DOC21/51284

29 January 2021

**Inland Rail – Narromine to Narrabri (SSI 9487)  
Advice on Environmental Impact Statement (EIS)**

Figure A8.5 Proposed location of out-of-hours works (map 1)

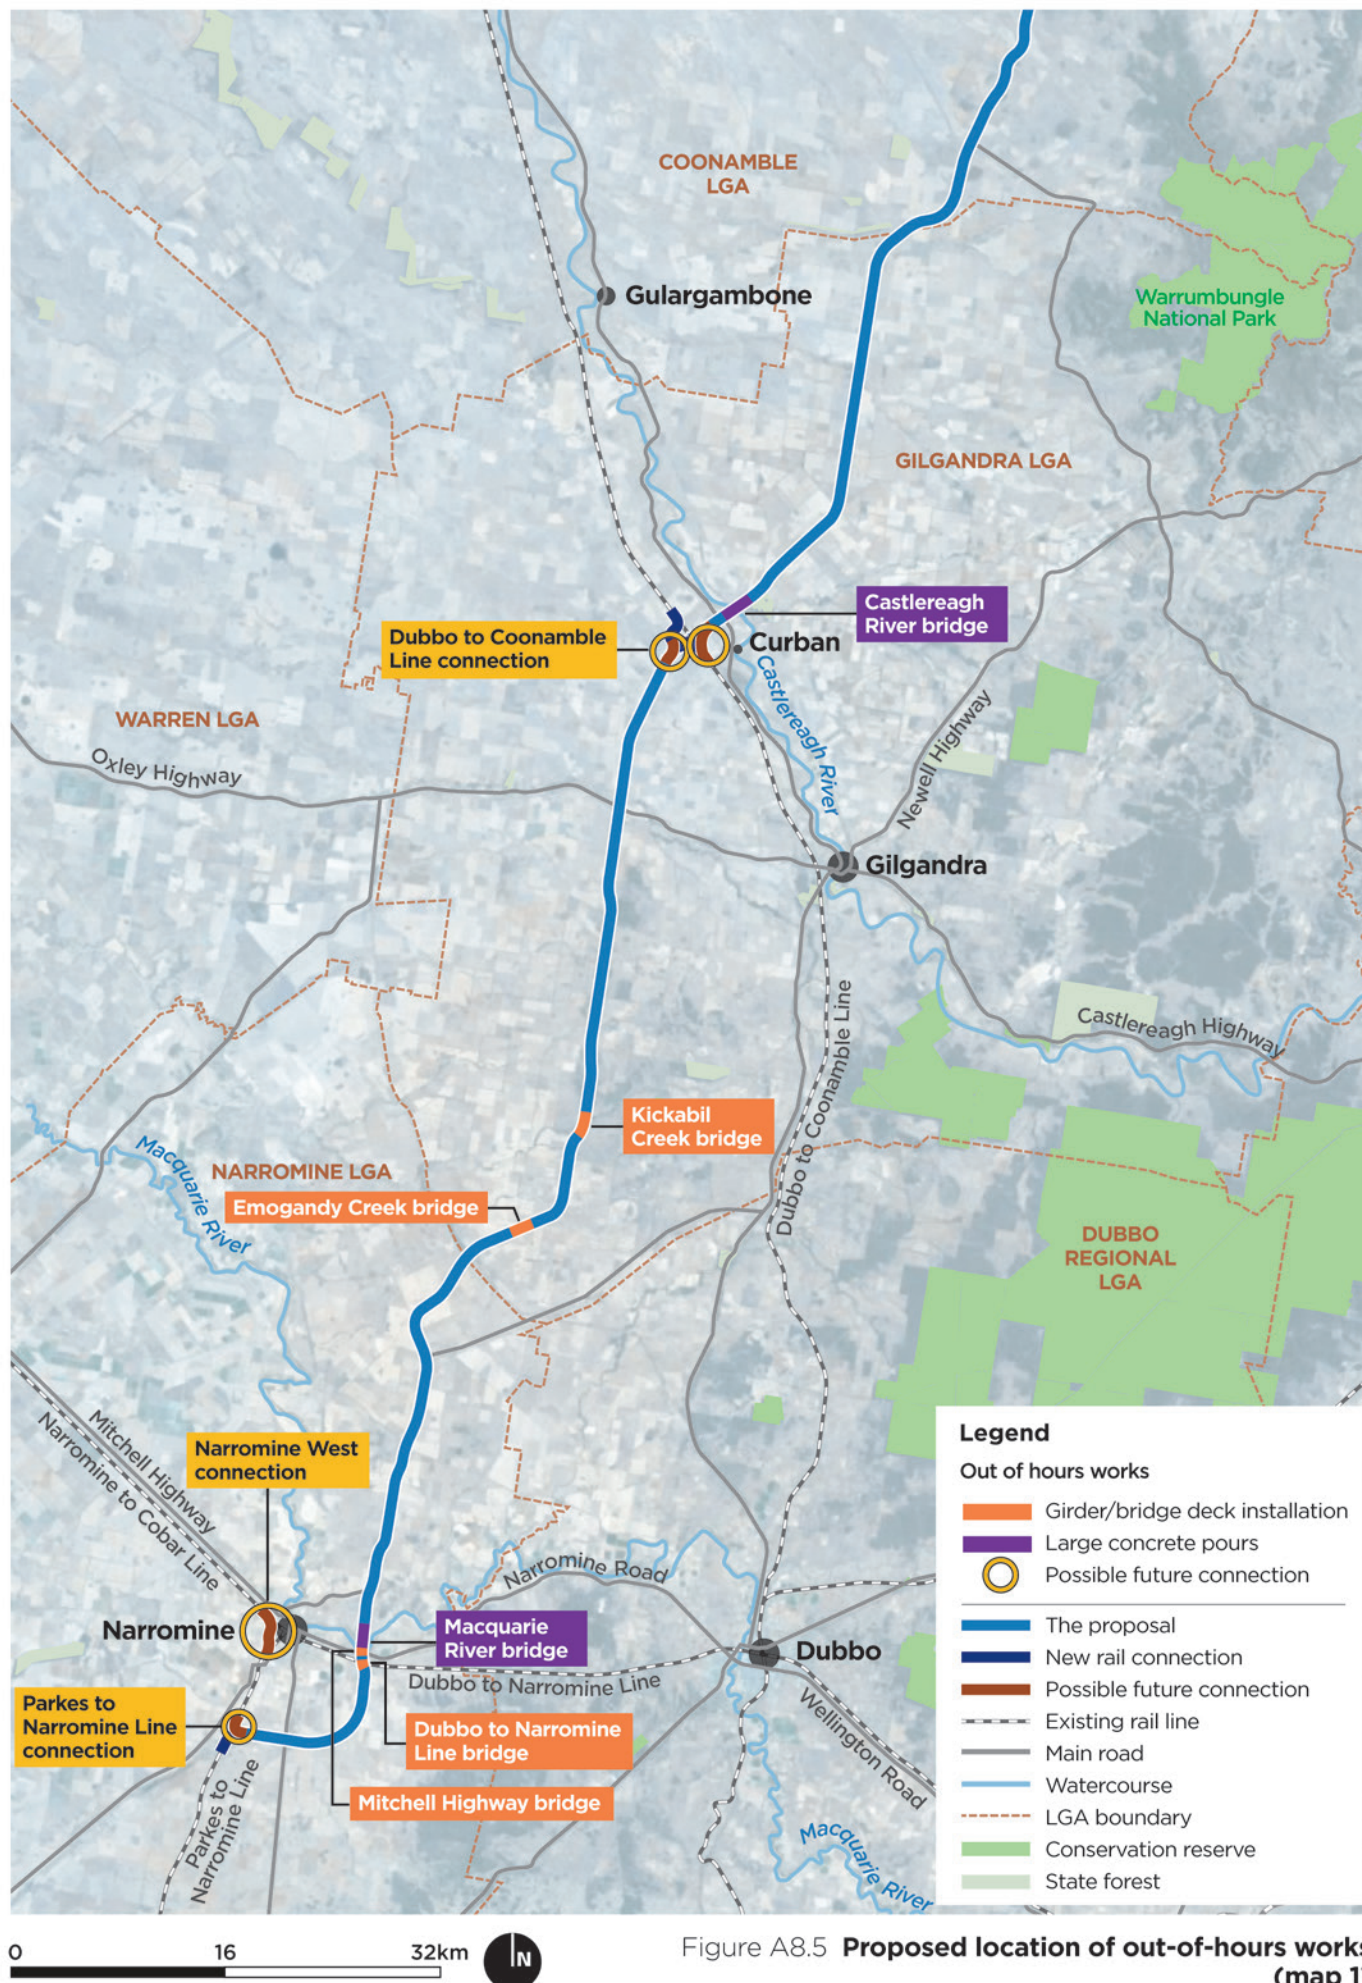
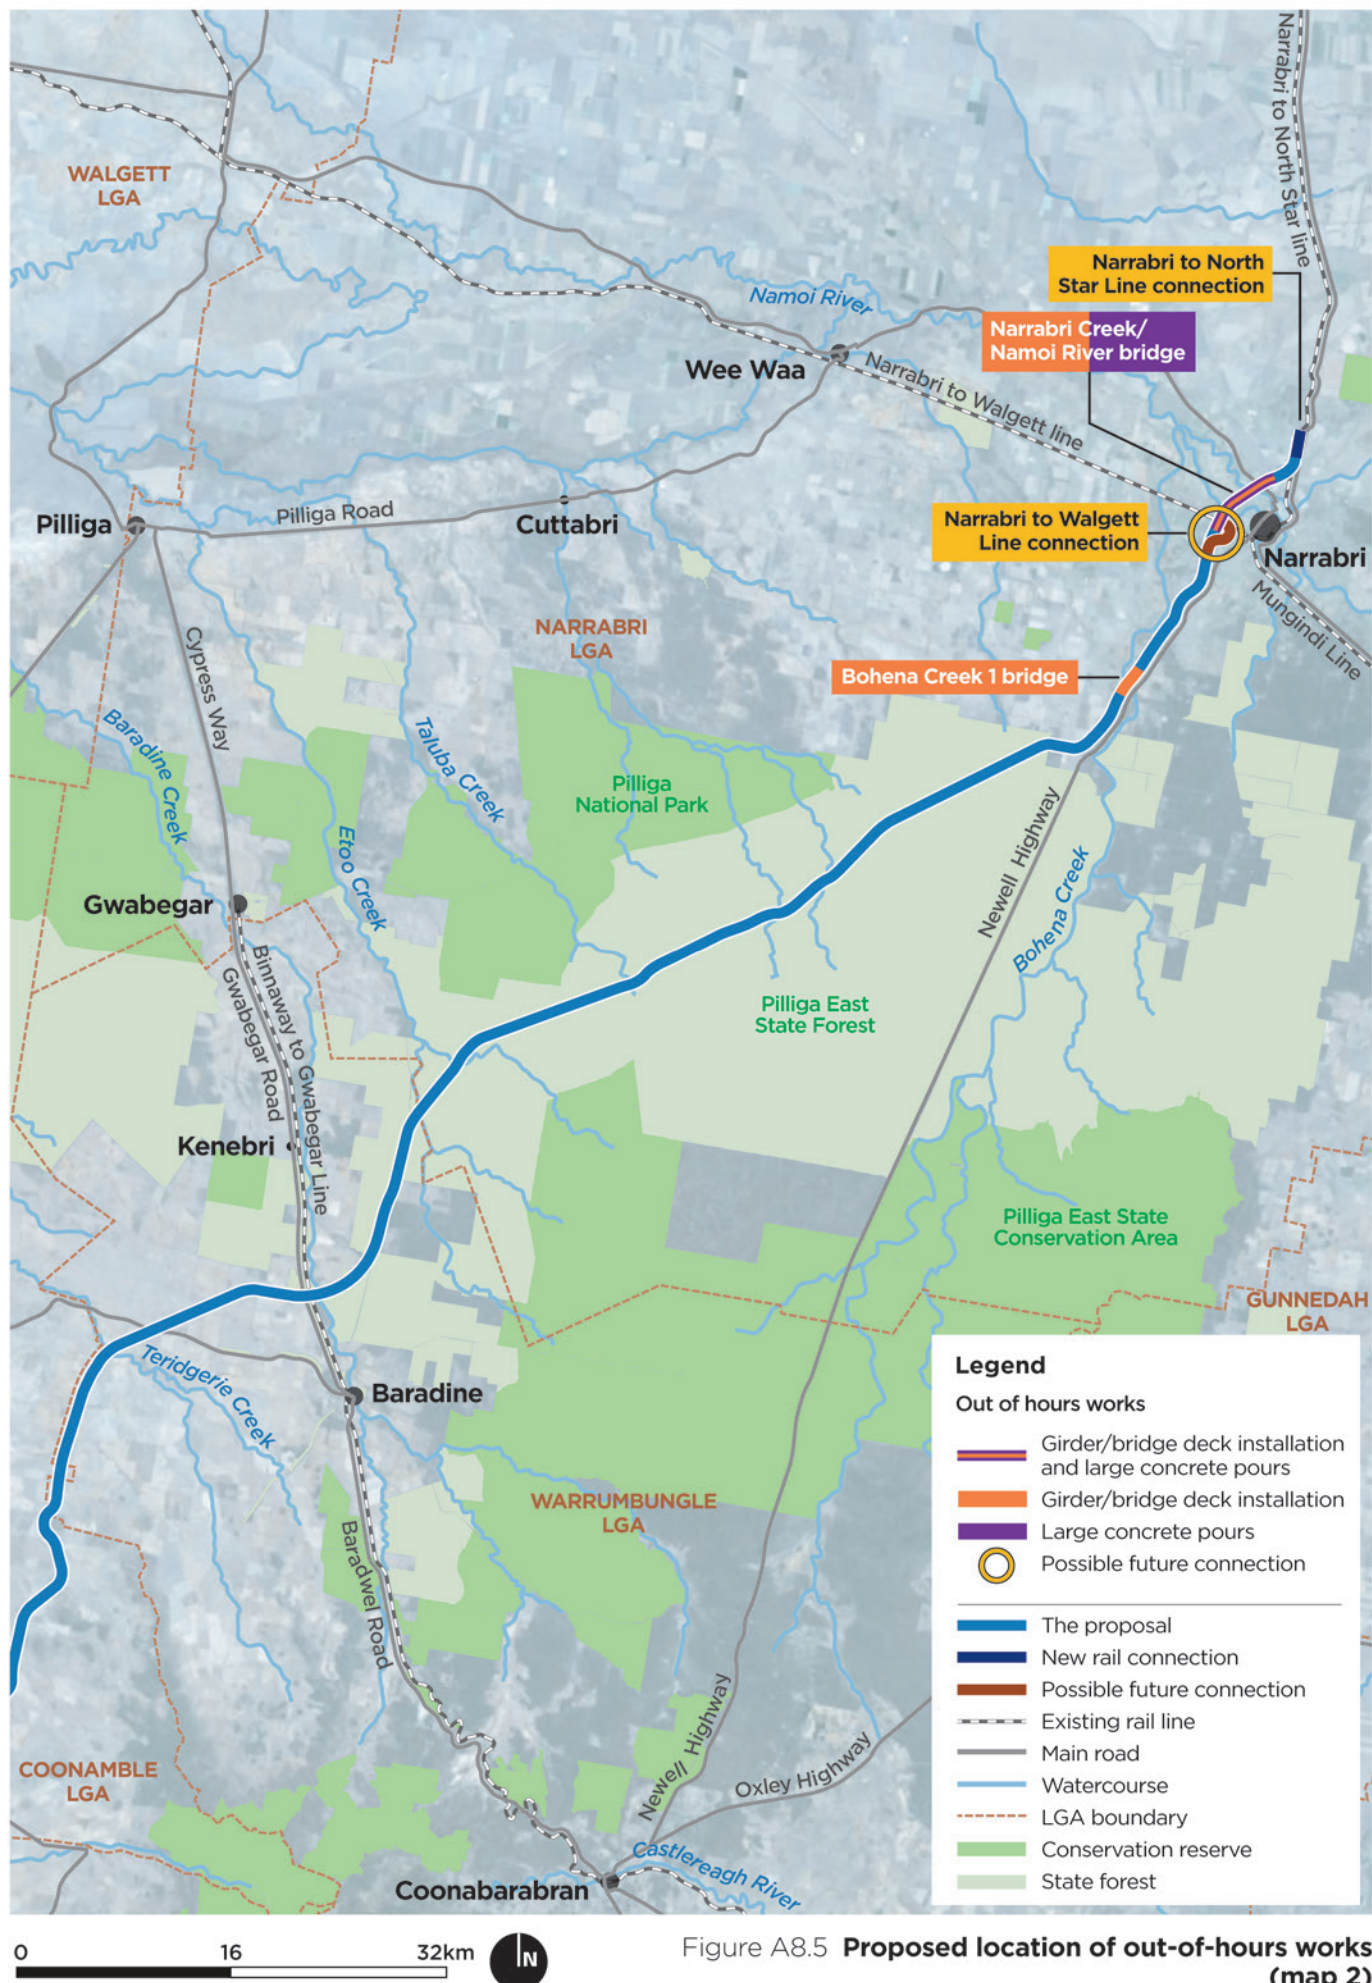
There does not appear to be sufficient justification to undertake work outside of standard hours within the CNVIA. **The EPA requests that further information and justification be provided if work outside of standard hours is proposed.**
